**Application for a non-material amendment following a grant of planning permission,
Town and Country Planning Act 1990**

**Non material amendment to previous permission 2020/90414 for erection of
detached garage**

43, Birkby Lodge Road, Birkby, Huddersfield, HD2 2BE

Application Number: 2020/92830

43 BIRKBY LODGE ROAD BIRKBY
DRG NO 1936-5D SCALE 1-50

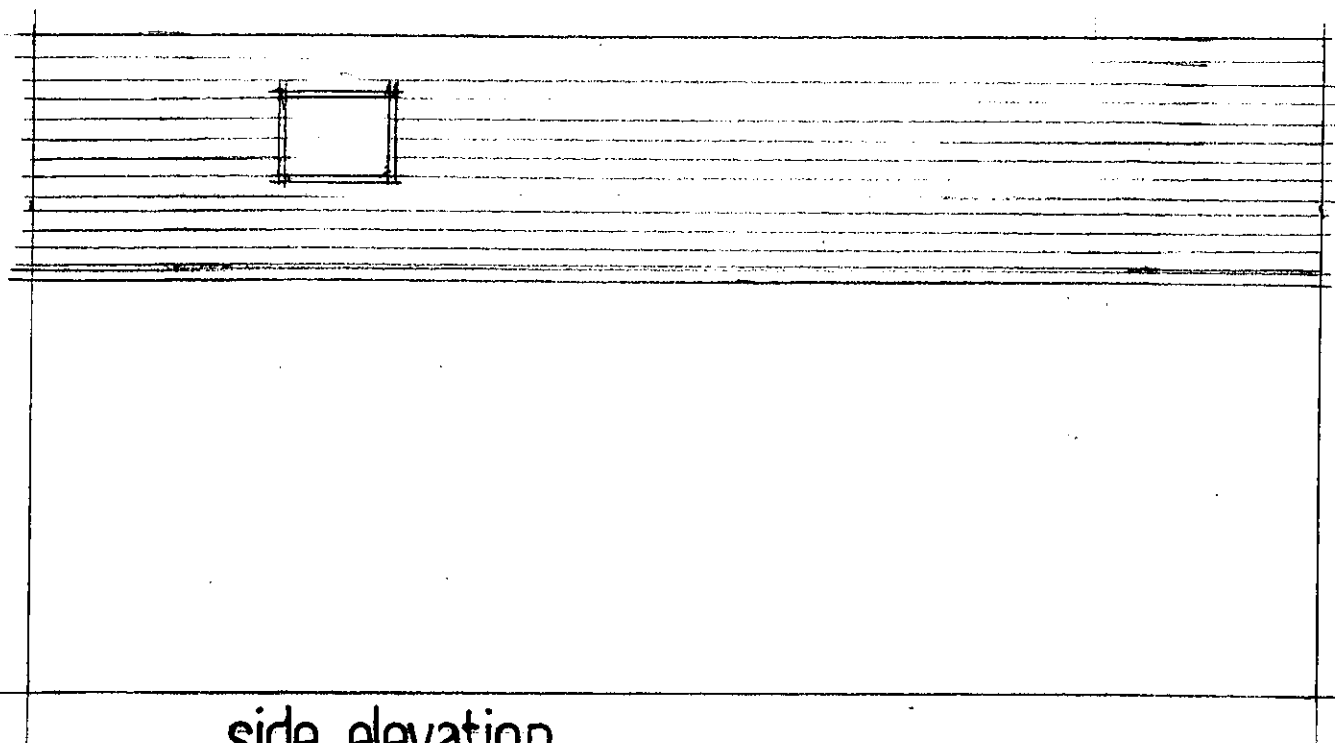
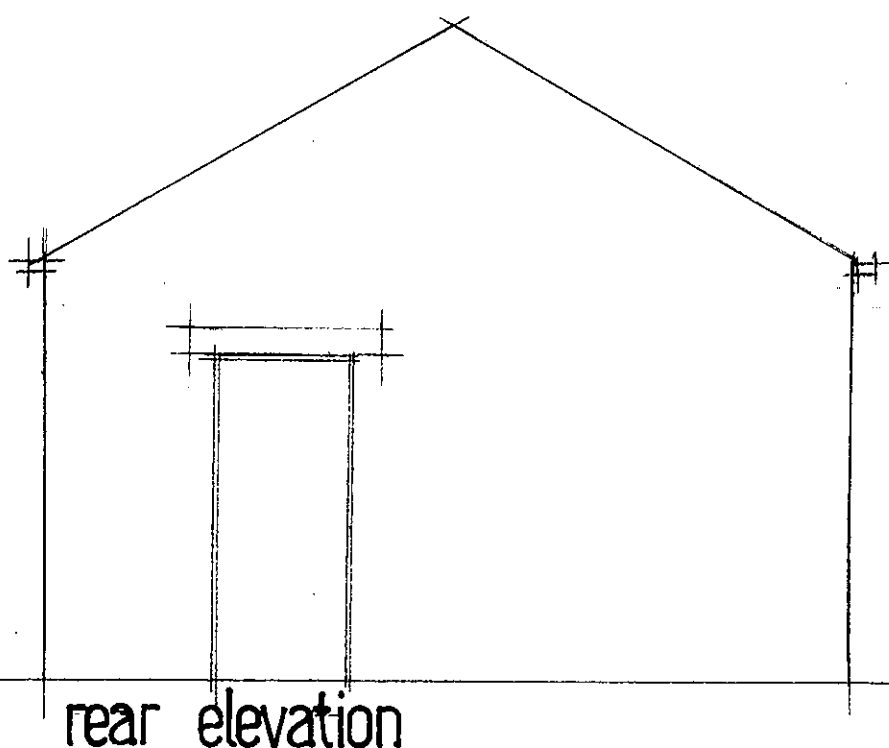
Thank you for your application dated 27-Aug-2020 for a non-material amendment to the above scheme. The amendment seeks to include two roof lights within the dual pitch roof as shown on plans 1936.4 D and 1936.5 Rev D.

I confirm that the alterations are acceptable and may be considered as a non-material amendment to the approved drawings. It should be noted that this letter relates only to the non-material amendment sought and it is not a re-issue of the original planning permission. The two documents should be read together and as such, all conditions imposed on the original granting of planning permission apply to the proposal as now amended. A copy of this letter and the amended plans will be retained on the public record of approved documents.
